February 20, 2023

Project Name / File No.: E Sunnyside PRD / PA22-033  
Applicant: JM1 Holdings, LLC  
Project Description: 28 Lot PRD-Subdivision  
Re: Response to 1<sup>st</sup> Review Comments

This letter serves as the Applicant's formal response to the 1<sup>st</sup> review comments received on October 7<sup>th</sup>, 2022, to our recent application materials submitted to the City of Marysville. To ensure that each of the comments have been responded to, we have incorporated each of the City's comments along with the Applicant's response to each below.

**RDI CALCULATIONS**

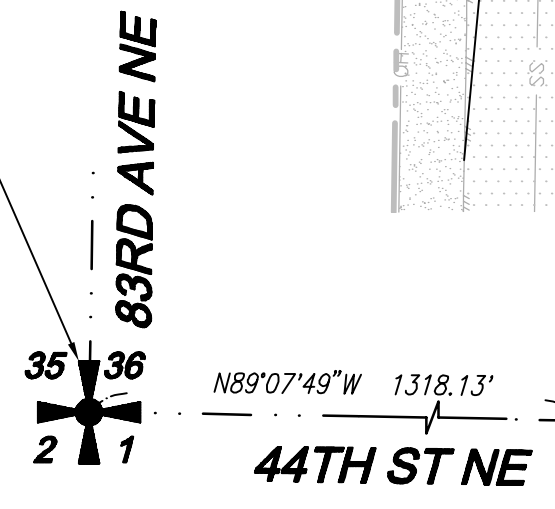
- The RDI Calculations on Sheet PP-01 and L-2 result in different incentive points; please revise for consistency.

**Applicant's Response: Drawings have been revised for consistency.**

VAULT ACCESS SECTION
SCALE: 1"=5'

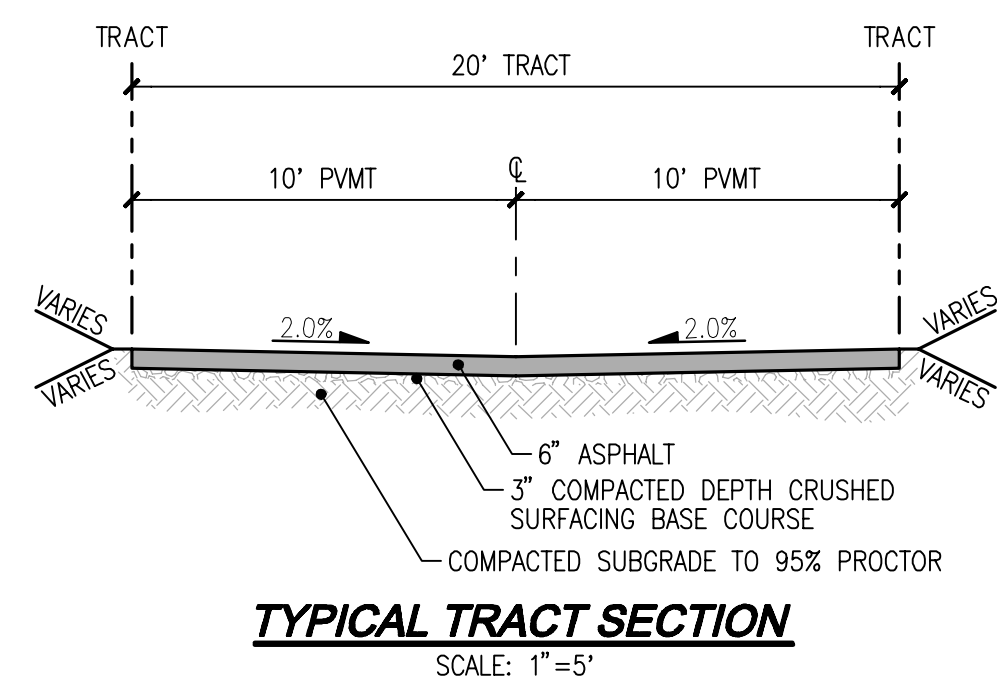
- 13.2. Location of precast vault lids need to be shown as well as proposed access to said lids.  
**Applicant's Response: Vault lids shown on landscape plan.**

**RDI CALCULATIONS**

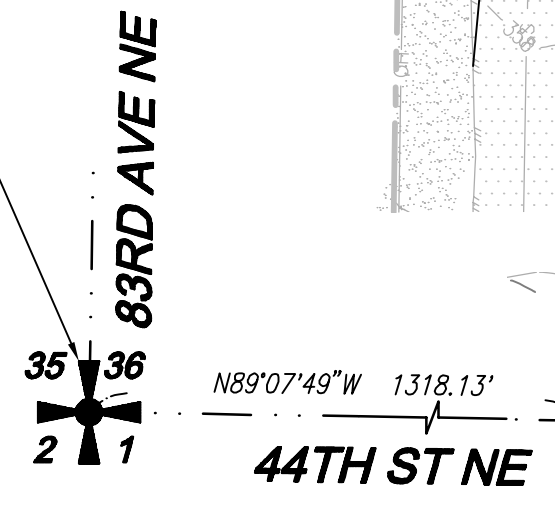
- To qualify for RDI bonus units under 6 (a) and (b), qualifying active/passive recreation must be clearly demonstrated.

**Applicant's Response: RDI bonus' for 6 (a) and (b) have been removed from the proposed project.**
